STAFF REPORT

LEGACY AT SUNCADIA PLAT (LP-17-00003)

TO: Kittitas County Board of County Commissioners
FROM: Kittitas County Community Development Services Staff
RE: Legacy at Suncadia Preliminary Plat (LP-17-00002)
DATE: May 2nd, 2017

SHEET
PP-02

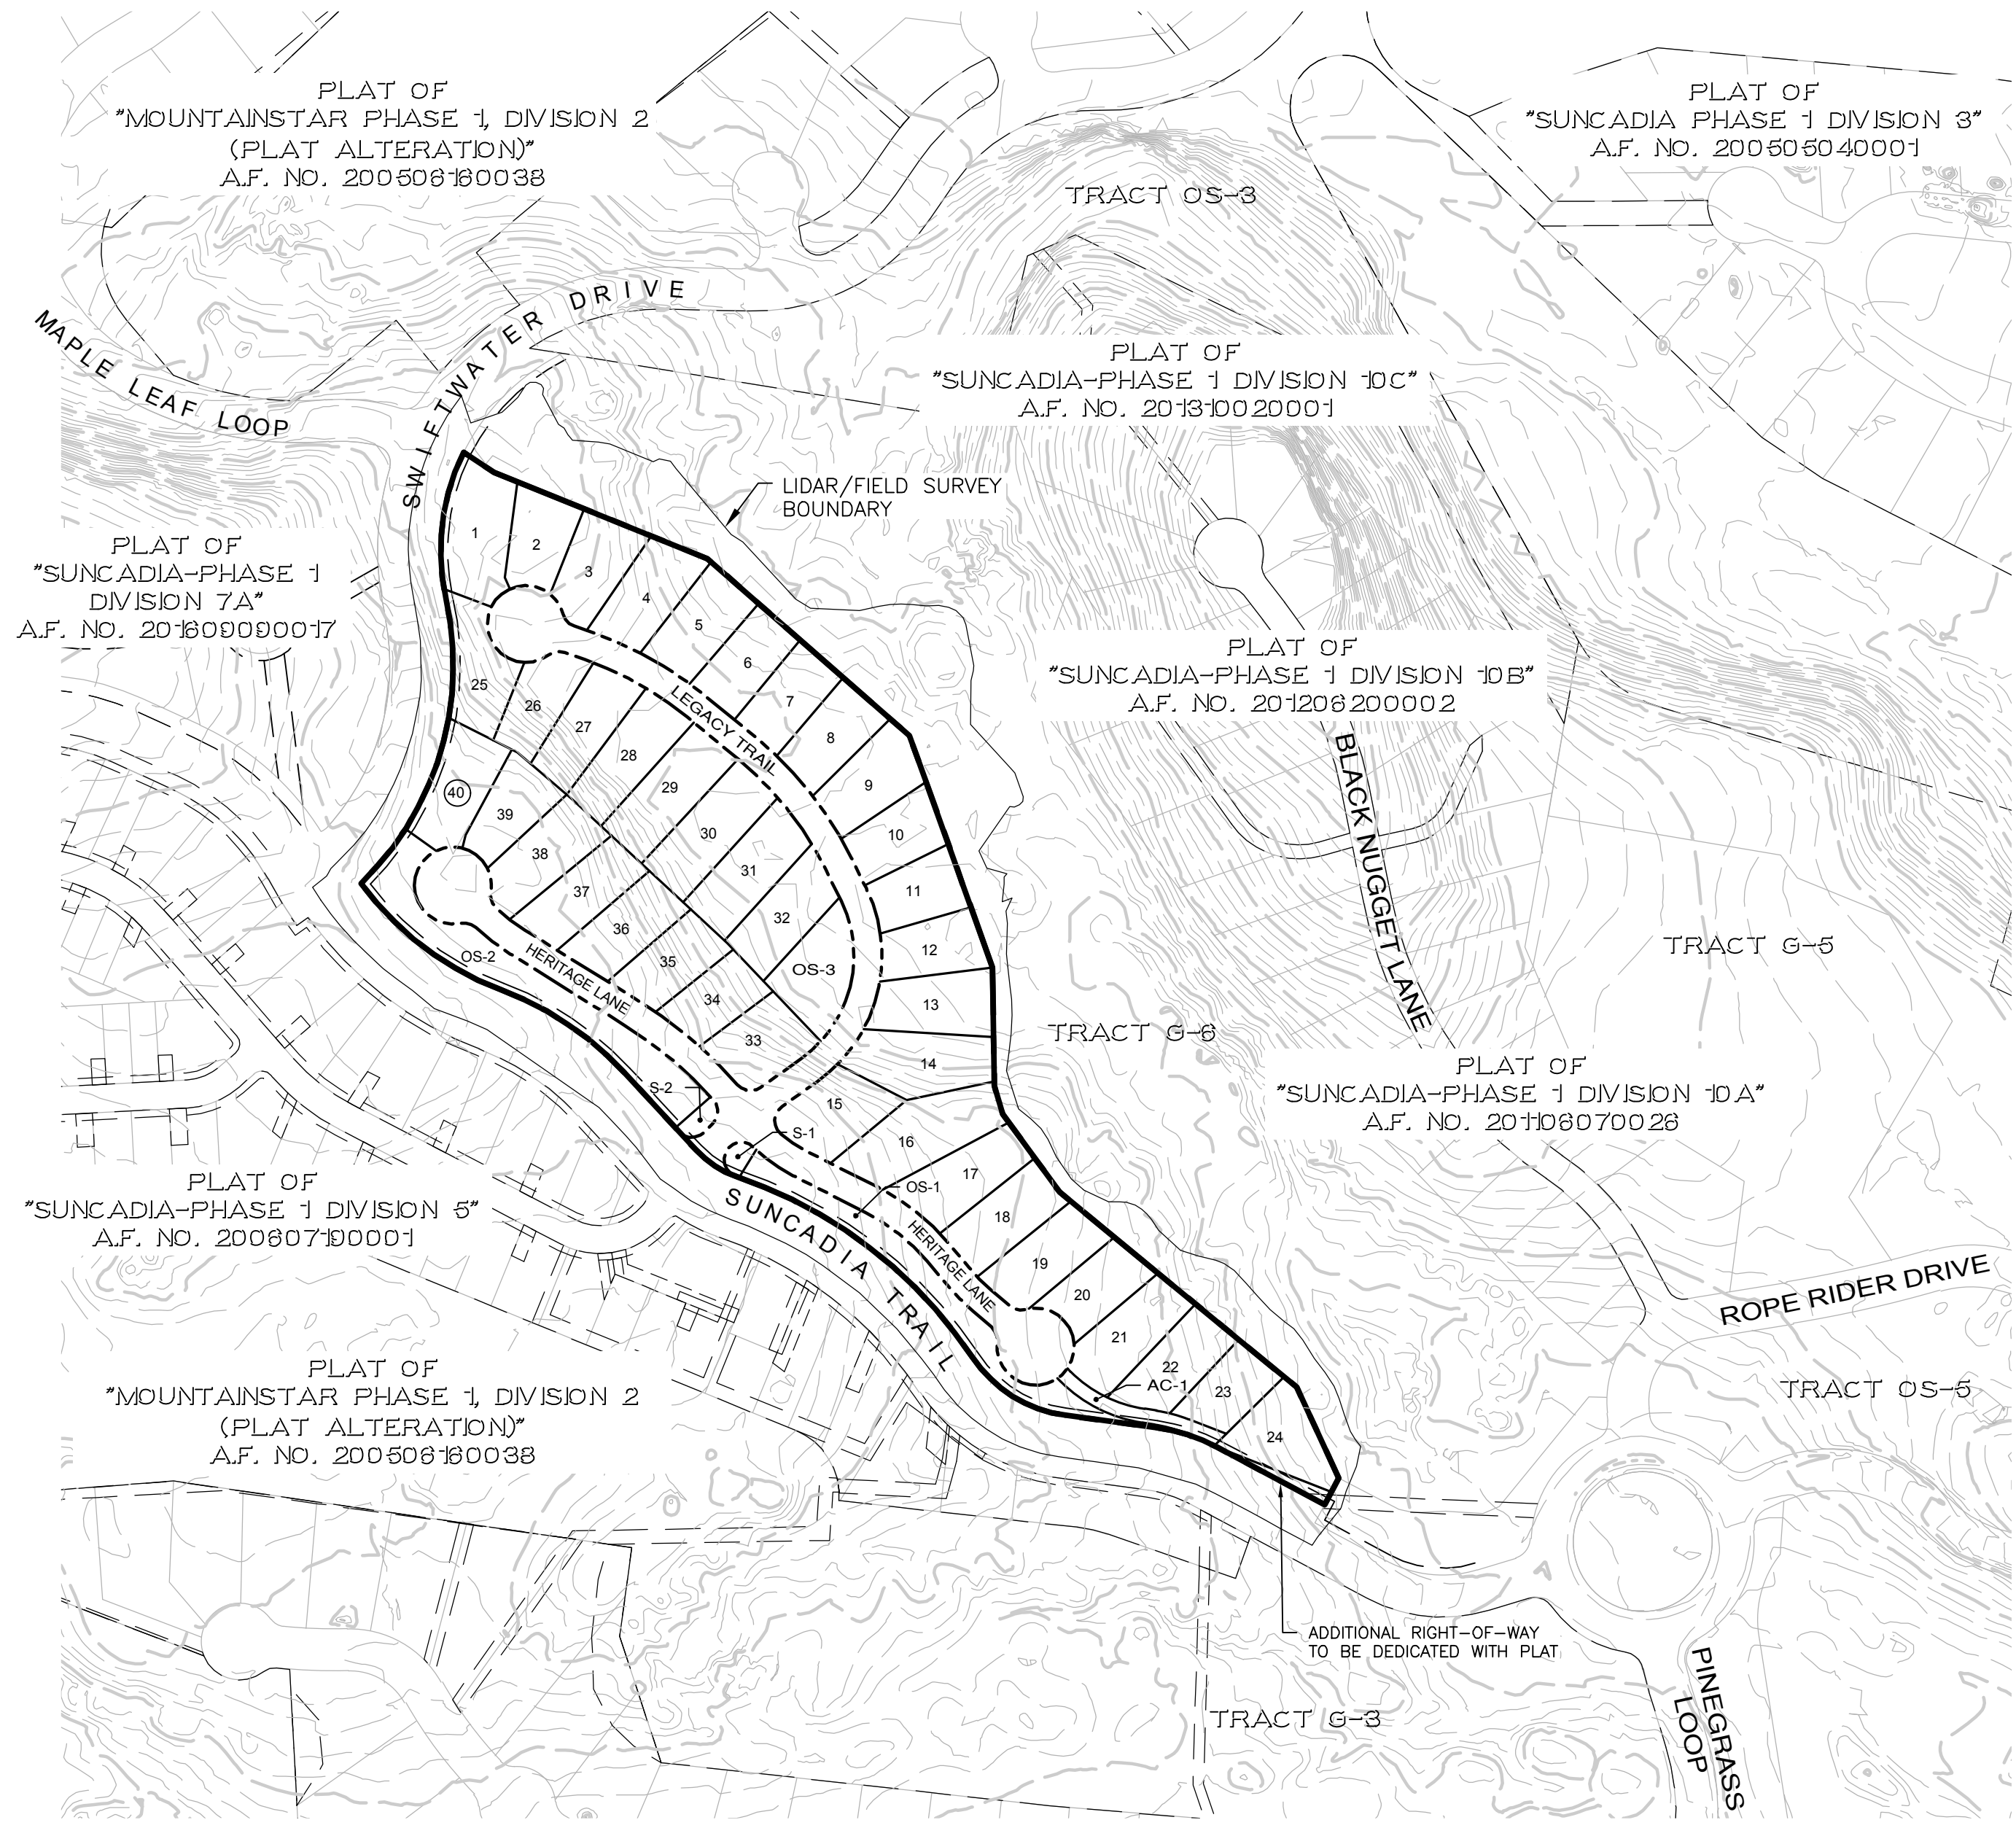
9. Lot and road dimensions are to be shown on the face of the plat.
10. The plat shall show all streams running through the property.
11. Private Road Naming: A Private Road Naming application will be required prior to final approval.

1. Lot and road dimensions to be shown on the face of the plat (KCC:16012.020(8)).
